Gatwick Northern Runway Project (Project Reference: TR020005)

Principal Areas of Disagreement Summary Statement (PADSS) – Version 4

East Sussex County Council (Registration Identification Number: 20044514)

Deadline 21 August 2024

ORIENTATION	DRAWING NO.	REVISION
	APPENDIX 13.6.1	For ES Issue
	FIGURE 2.3.1	
	DRAWN BY	PM / CHECKED BY
	SG	CD

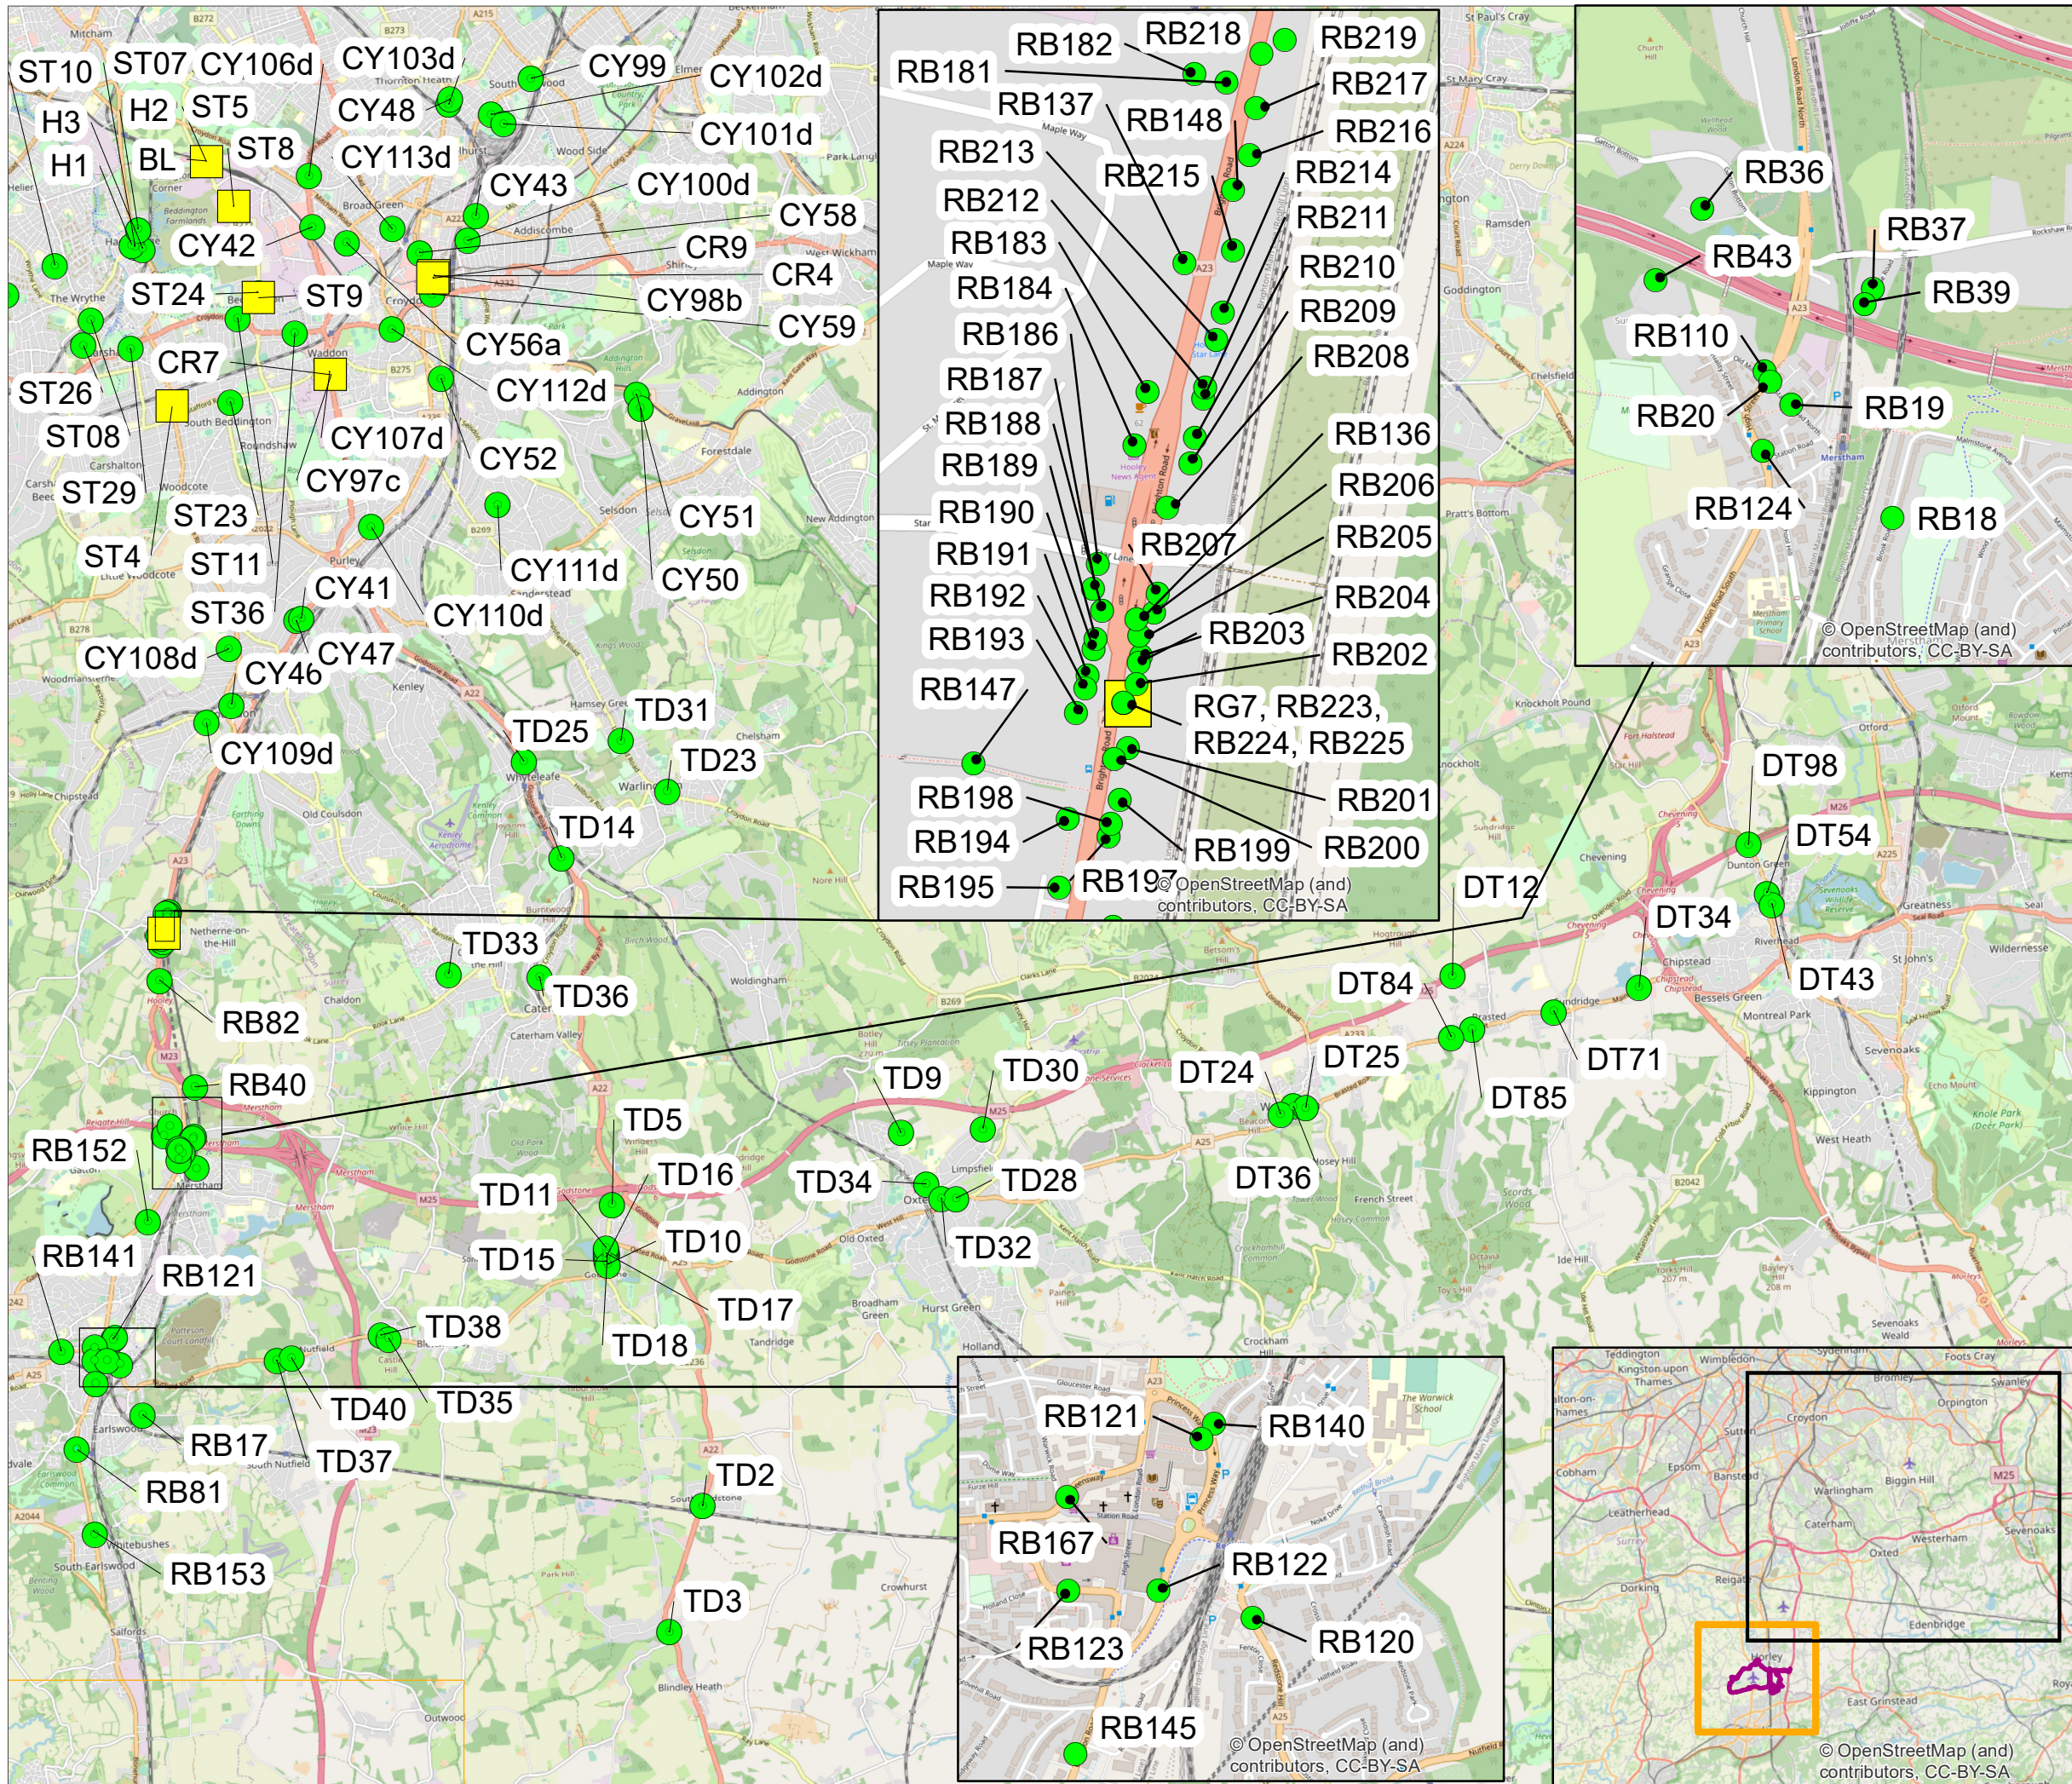
Principal Areas of Disagreement Summary Statement (PADSS) from East Sussex County Council		Version Number: 1 Submitted at: October 2023 Updated: August 2024	
		<p>Currently, figures within Part 3 just show a wider study area domain, not the actual roads meeting the ARN criteria (e.g. Appendix 13.6.1 Figure 2.3.1). This figure should be provided to illustrate the affected road network. No further information on the road traffic air quality study was identified in ES Appendix 13.4.1: Air Quality Assessment Methodology. However, reference to the above missing figure is made within this ES Appendix document, suggesting it has been missed in the collation of this ES Appendix.</p>	
13	Operational monitoring should be agreed during the examination.	<p><i>Document 5.1, Chapter 13</i></p> <p>Operational monitoring will be crucial to understand if measured air quality is following modelled prediction.</p>	<p>The Applicant sets out in paragraph 3.7.7 of their Response to Deadline 3 Submissions [REP4-031] that the air quality matters submitted by the Joint Local Authorities at Deadline 3 (Appendix A) [REP3-117] will be responded to by Deadline 5. This Appendix of air quality queries prepared by AECOM included a wide range of technical matters. The Joint Local Authorities have also submitted a detailed review of the Air Quality</p>
